**MP07_0162 - Warner Industrial Park
 Preferred Project Report**

This correspondence is in response to the exhibition of the Preferred Project Report for the Warner Industrial Park (application No. MP07_0162).

MP07_0162 - Warner Industrial Park Public Exhibition Wyong Shire Council Submission

<i>P.J.</i>	5.06.08	PROJECT NUMBER	DRAWING NO	REVISION
ENGINEERING DESIGNER	DATE	19426	EA01	J

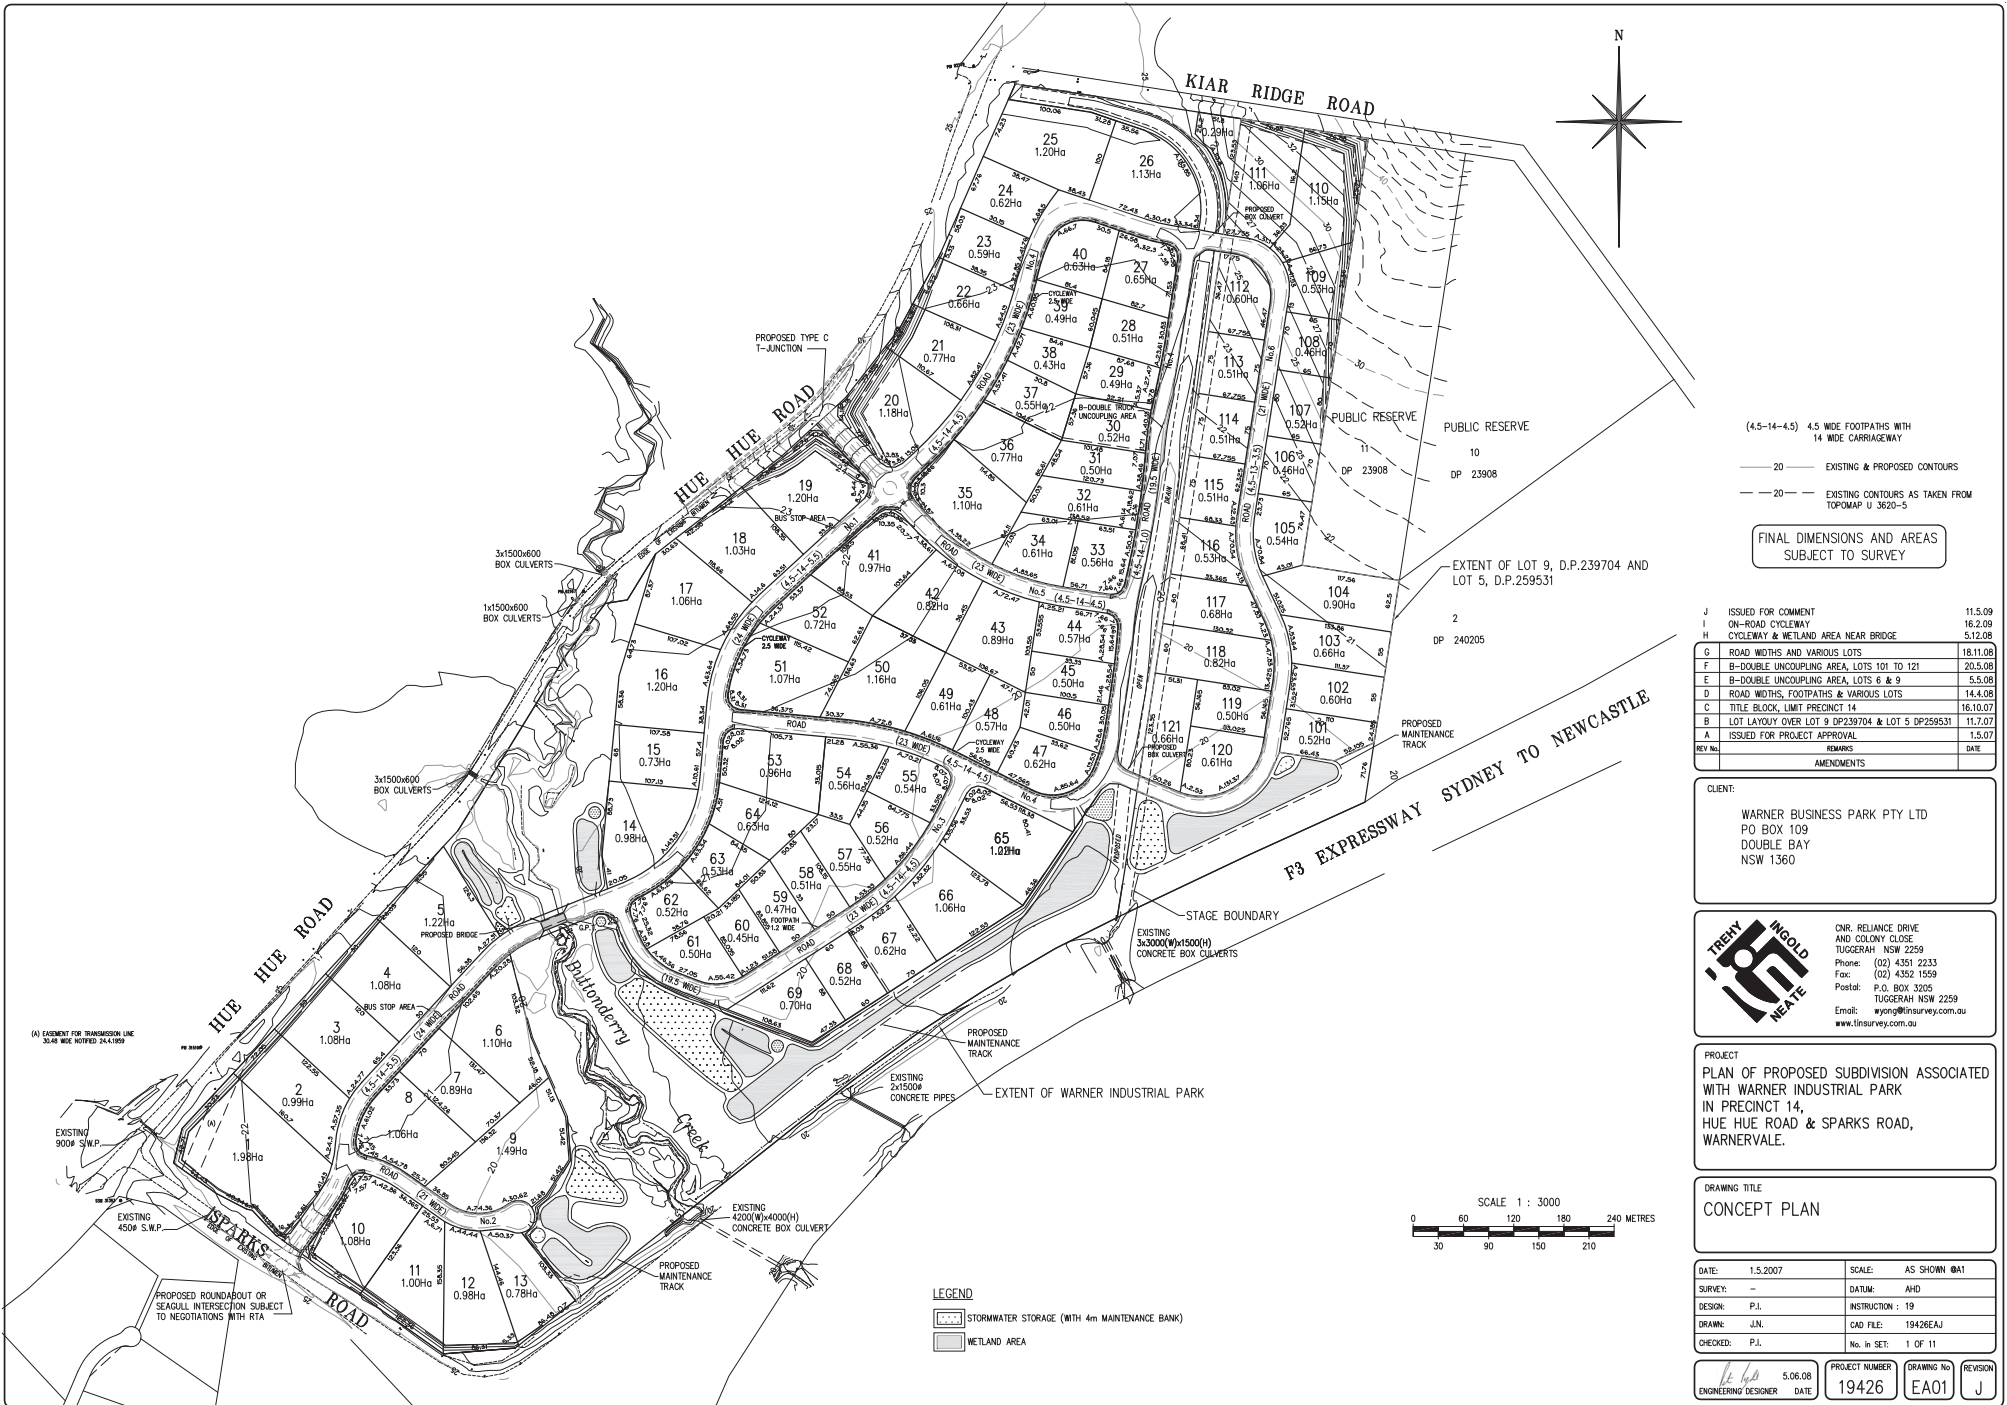
17. Access to Hue Hue Road and Sparks Road, with the exception of the two intersections shown on the Concept Plan, EA01, Revision F, is denied.

19. Construction of the intersections shown on the Concept Plan, EA01, Revision F on Sparks Road and Hue Hue Road are to be at full cost to the developer.
